**Consultation Response from KC,
Lead Local Flood Authority**
2022/91880 The Richardson Arms, 684, Bradford Road, Oakenshaw, BD12 7EN
Erection of residential development
Date Responded: 16/09/2022
Responding Officer: Martin Stephenson
Responding Ref: 0
Documents reviewed by the LLFA:

- Drawing Ref: AGC/11/408/020, Proposed Site Plan, Revision – dated May 2022

| Proposed Site Plan |

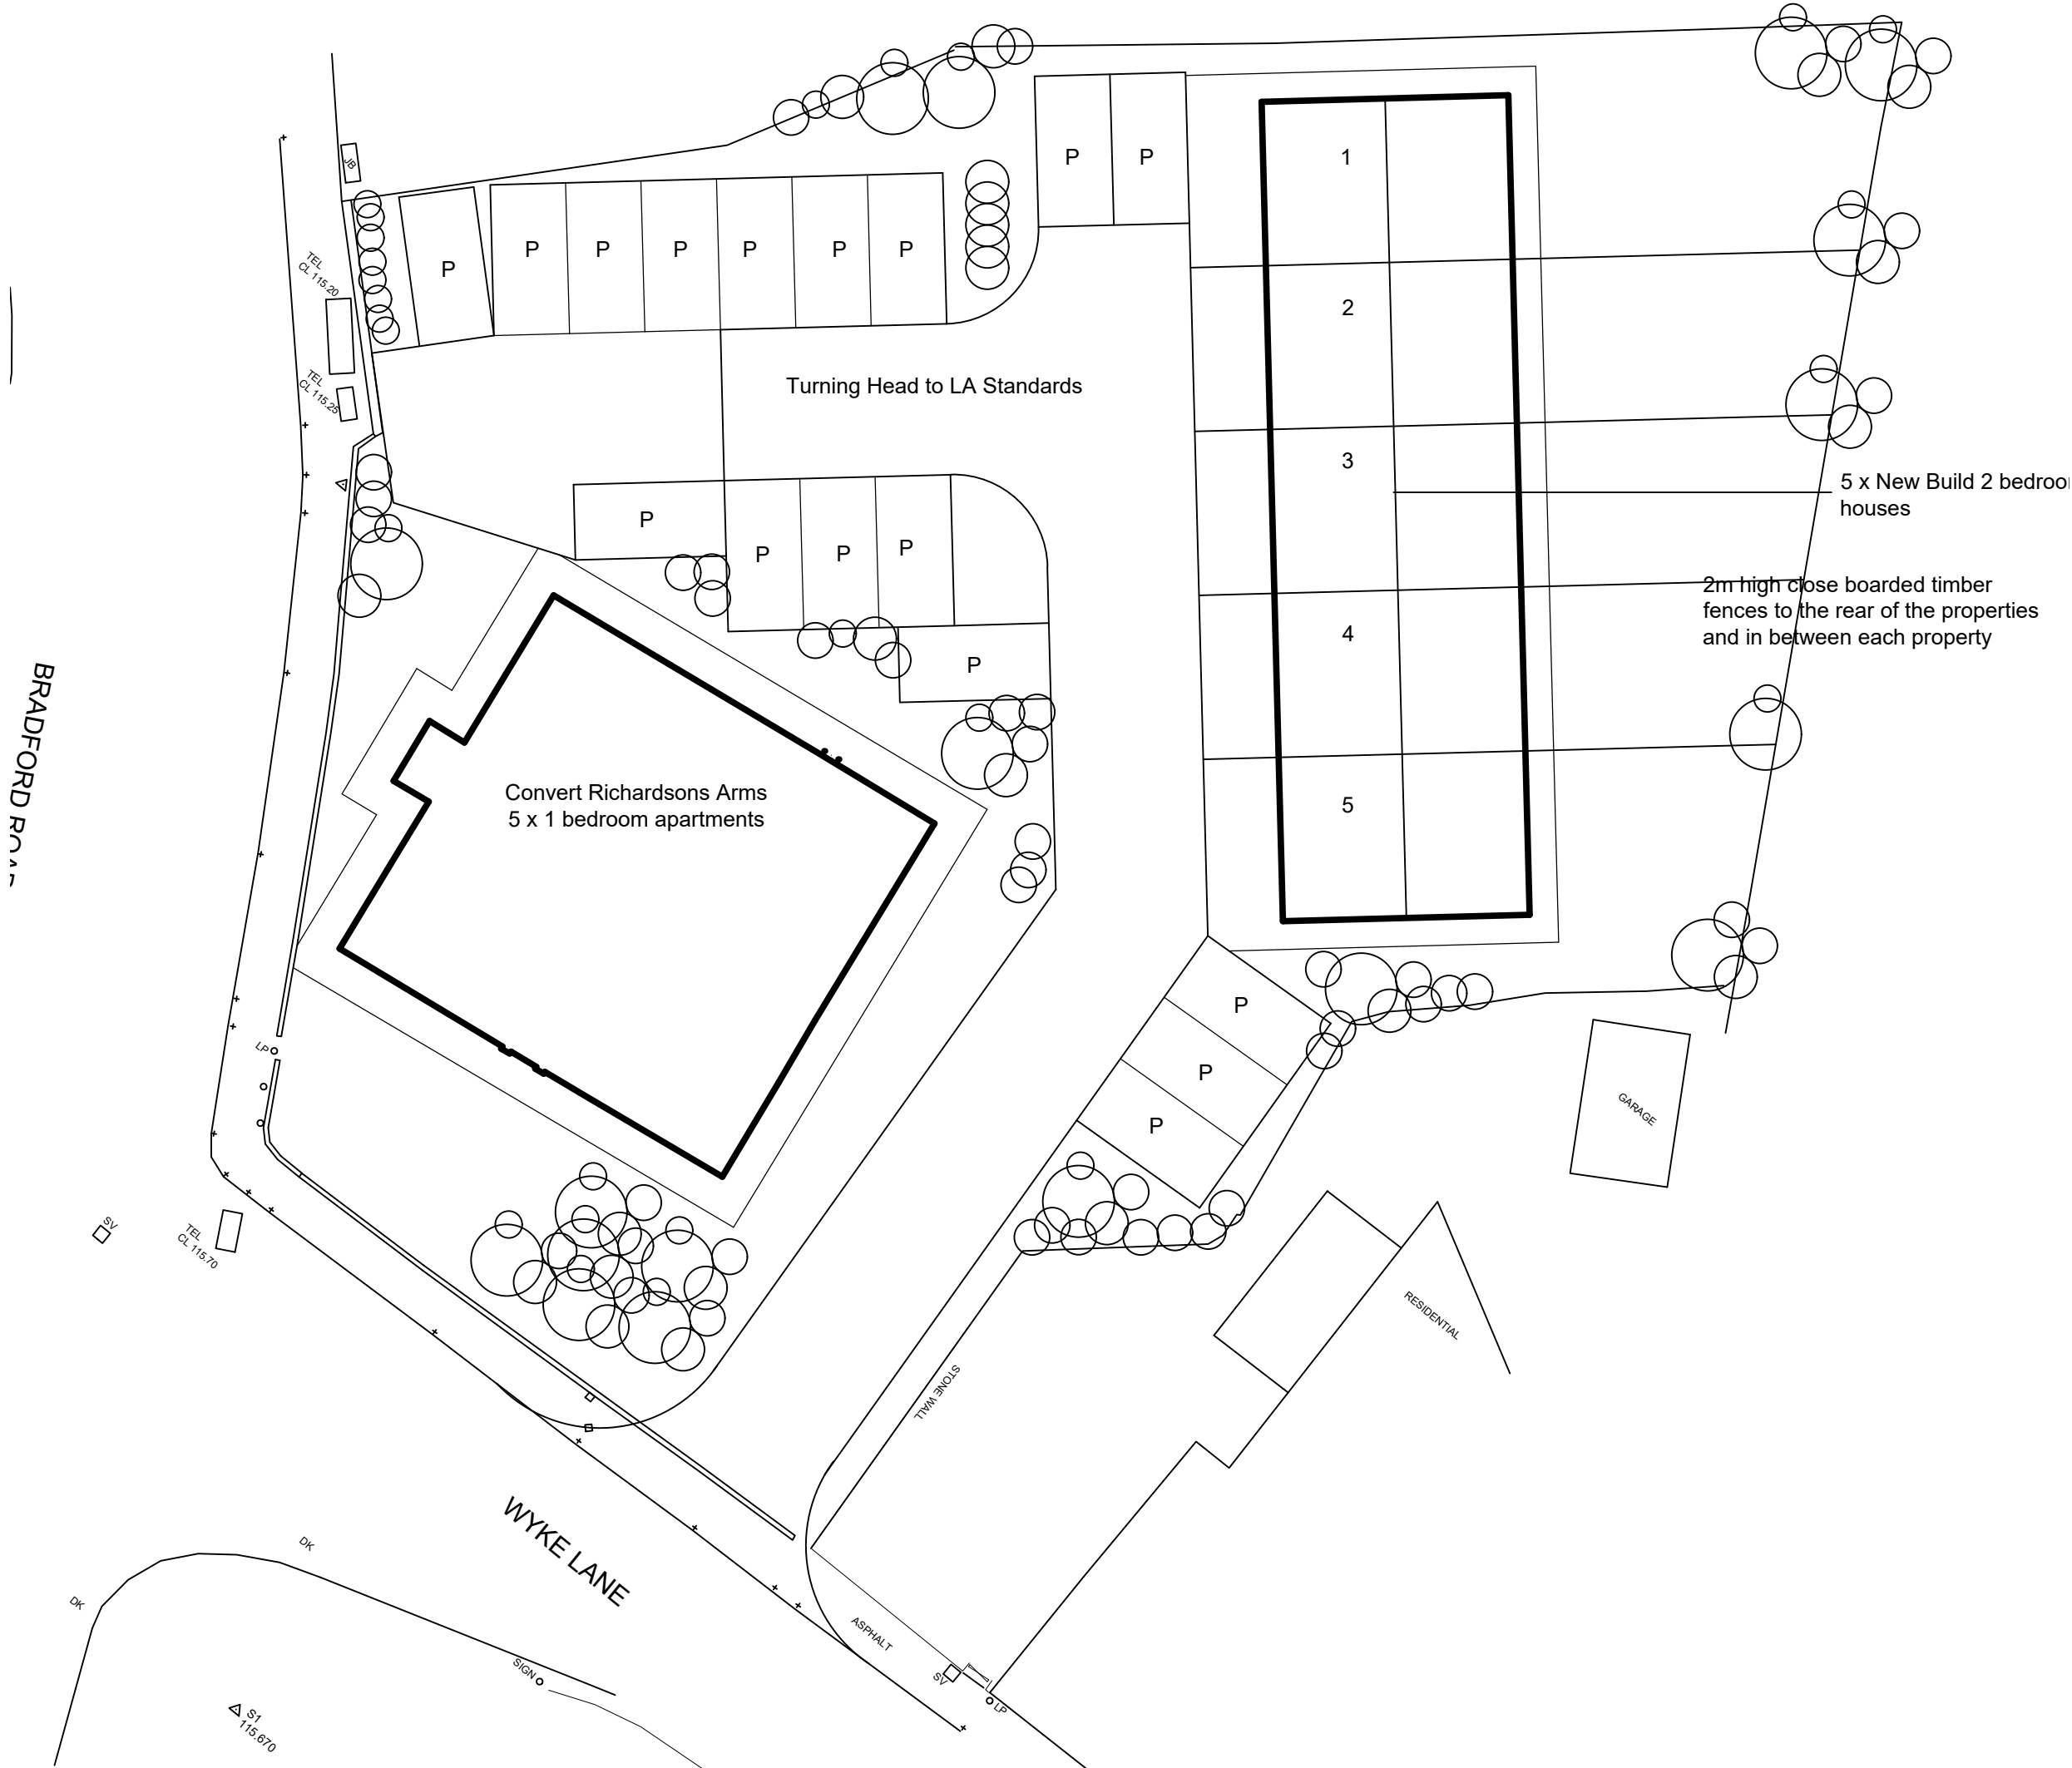
The area of the proposed development, minus the area of the retained building, has been measured to be 1,525m² which results in an estimated unattenuated surface water run-off rate of 21.2 l/s for the 1 in 2 year rainfall event. The LLFA requires that there shall be a 30% reduction to redeveloped brownfield sites which would give an allowed discharge rate of **14.8 l/s**.

Attenuation storage to contain within the proposed development site the critical 1 in 100 year rainfall event plus 30% climate change allowance should be provided such that no flooding occurs to the proposed or existing building.

Details of the proposed surface water drainage Maintenance Plan should be submitted detailing the proposed Maintenance Schedule of the system and the method of access to the pond and flow control device. The organisation that will be responsible for maintenance up to adoption by the statutory water authority should be identified. It is recommended that this will be included in a Section 106 agreement between the developer and the Council.

Development shall not commence until a detailed design scheme detailing foul, surface water and land drainage, including agreed discharge rates with the LLFA of **14.8 l/s** indirectly or directly to watercourse, attenuation for the critical 1 in 100 + 30% climate change rainfall event, attenuation construction details /design, plans and longitudinal sections, hydraulic calculations, phasing of drainage provision) has been submitted to and approved in writing by the Local Planning Authority. The scheme shall include a risk assessment and method statement, in accordance with CDM Regulations 2015, for access to and into the attenuation structure, and an itinerary of maintenance tasks with schedules. No part of the development shall be occupied until such approved drainage scheme has been provided on the site to serve the development or each agreed phasing of the development and retained thereafter.

The development shall not commence until an assessment of the effects of 1 in 100 year storm events, with an additional allowance for climate change, blockage scenarios and exceedance events on drainage infrastructure and surface water run-off pre and post development between the development and the surrounding area (both upstream and downstream of the development), has been submitted to and approved in writing by the Local Planning Authority. No part of the development shall be brought into use (dwellings shall not be occupied) until the works comprising the approved scheme have been completed and such approved scheme shall be retained thereafter.
